**Consultation Response from KC,
Highways Development Management**

2024/90346 Future House, Pheasant Drive, Birstall, Batley, WF17 9LT

Change of use to Class B2 for use as industrial transport yard, with associated new office building, new fencing including new pedestrian and vehicular gates, widening of vehicular access, including re-surfacing of yard and access threshold, and new lighting to yard

Date Responded: 25-3-2024.

## Proposed Plans

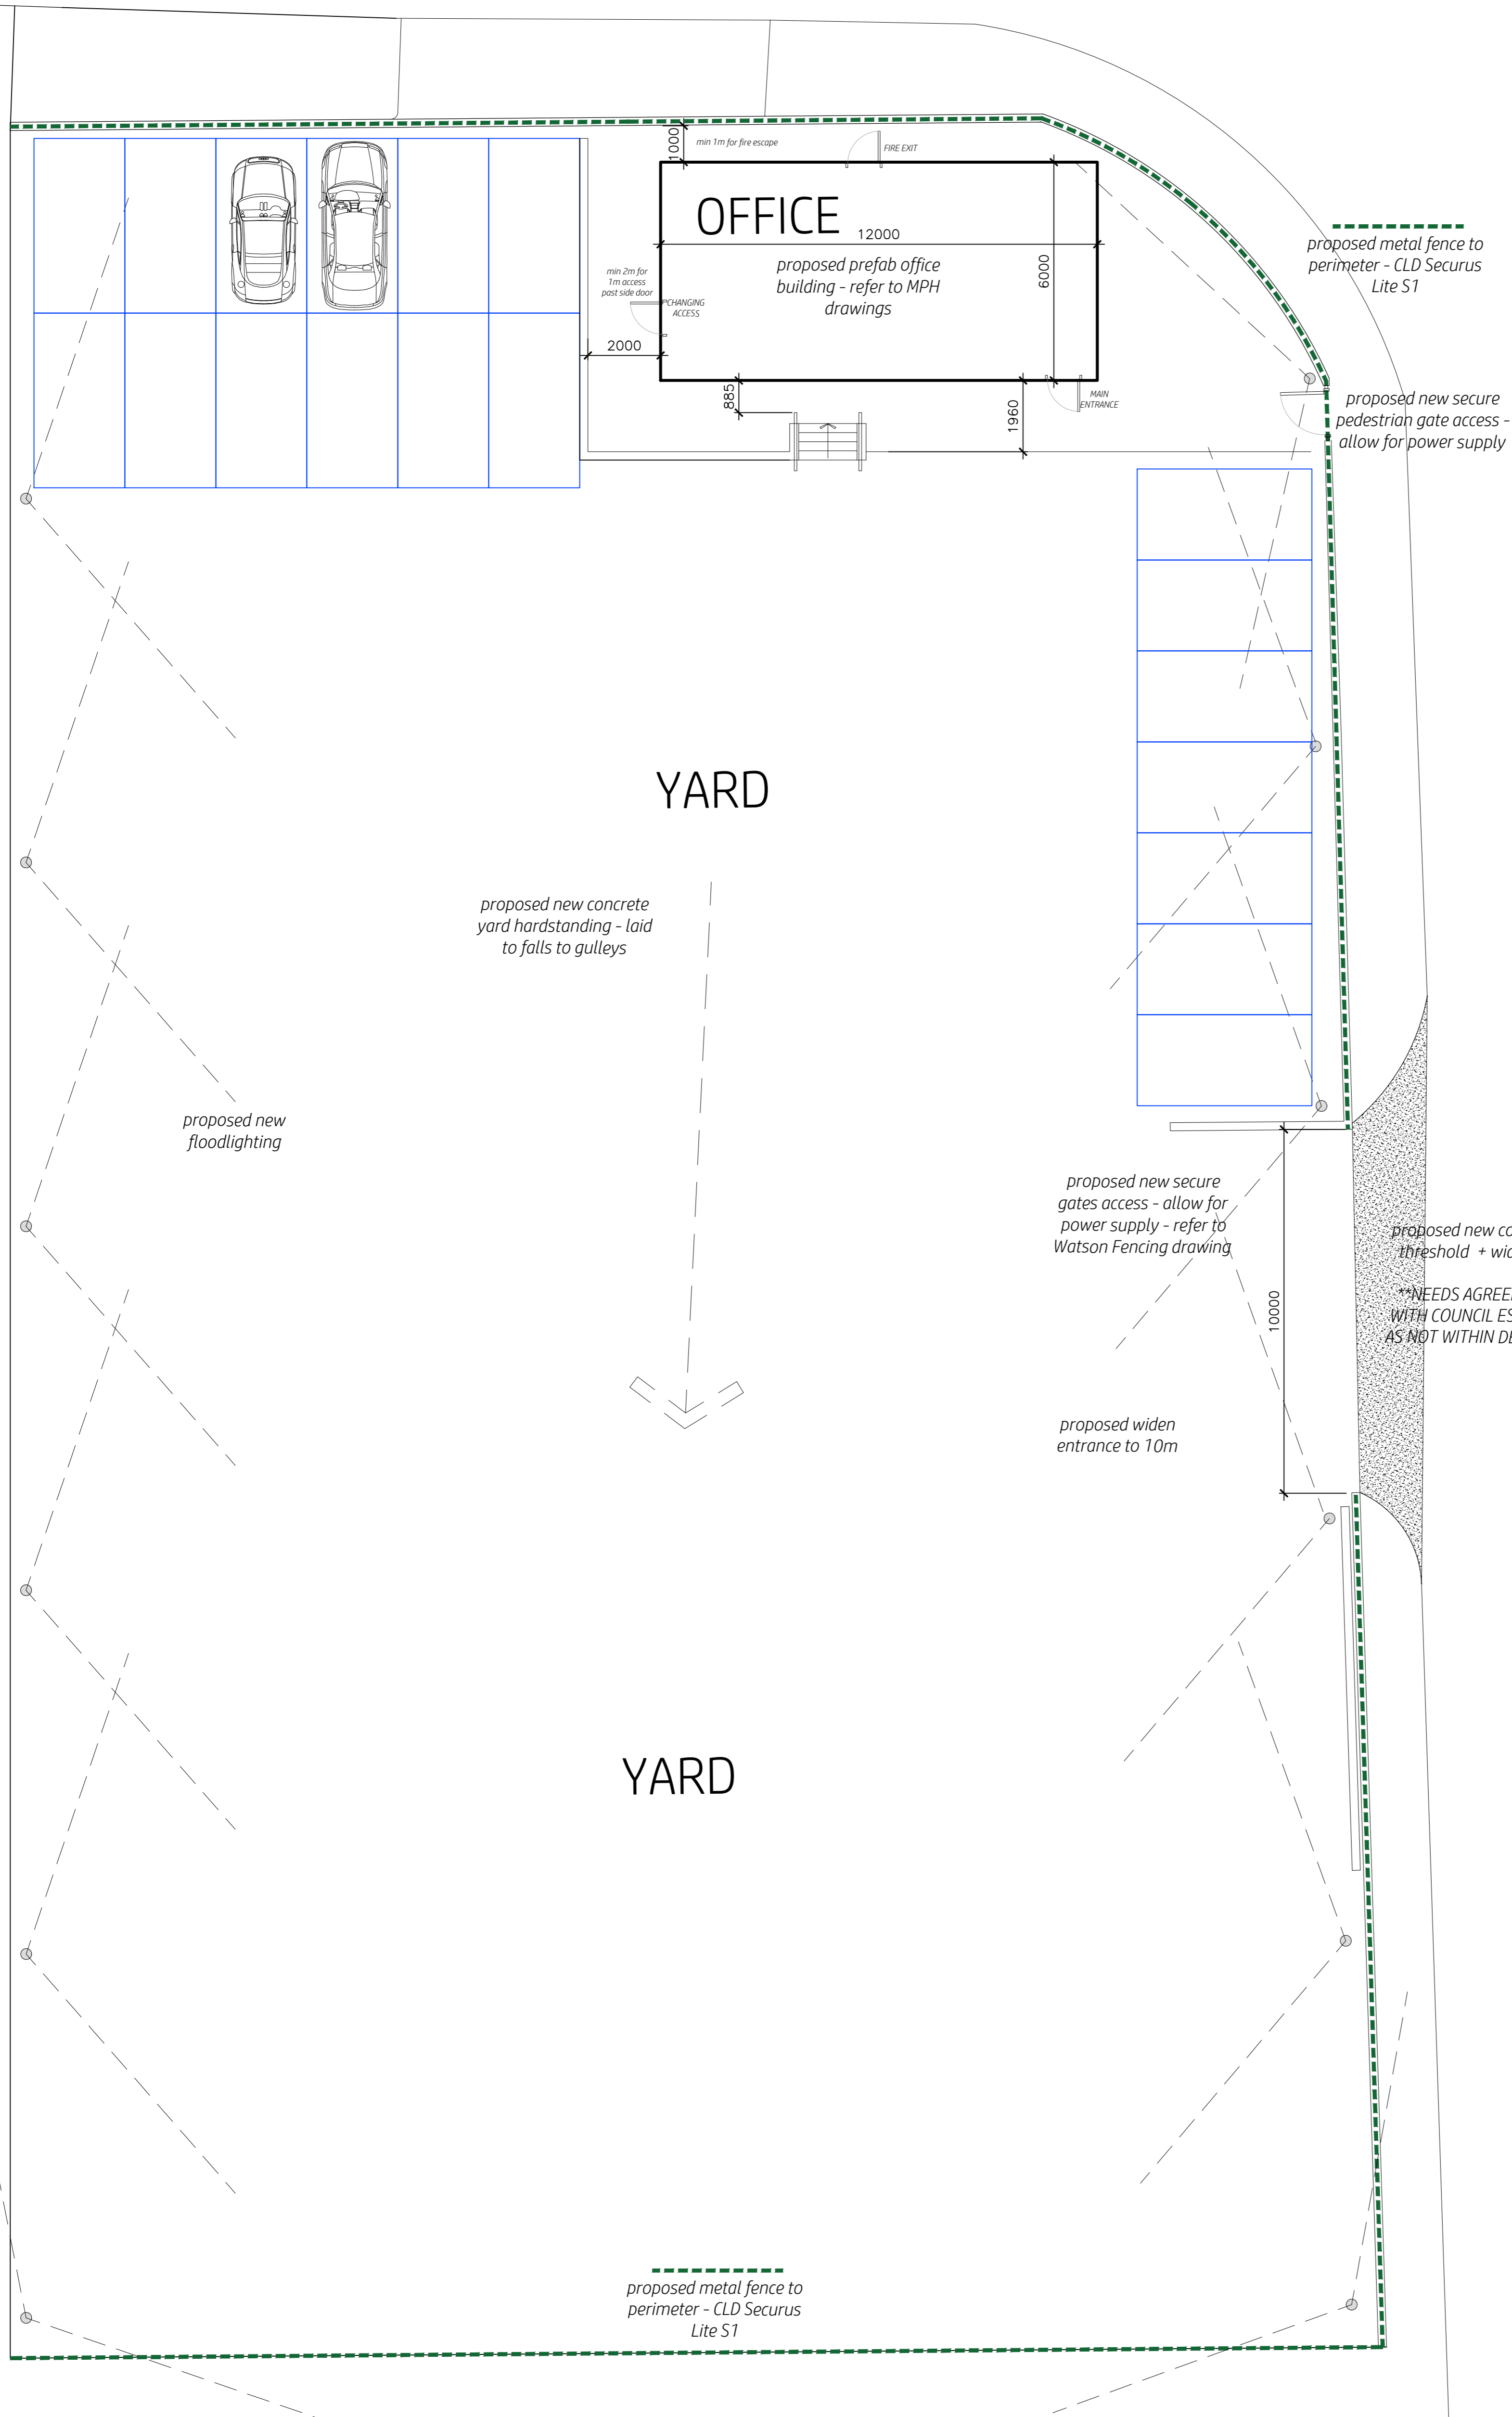
This application provides insufficient information to allow a proper highway assessment to be undertaken.

Can the applicants be asked to explain how this proposal will operate and provide details of the numbers of HGVs that will operate from the premises and provide details of their parking arrangements.

Vehicle swept paths should also be provided to demonstrate that the largest vehicle anticipated to access this site regularly (16.5m articulated lorry) can enter and ,exit from Pheasant Drive and turn within the site.
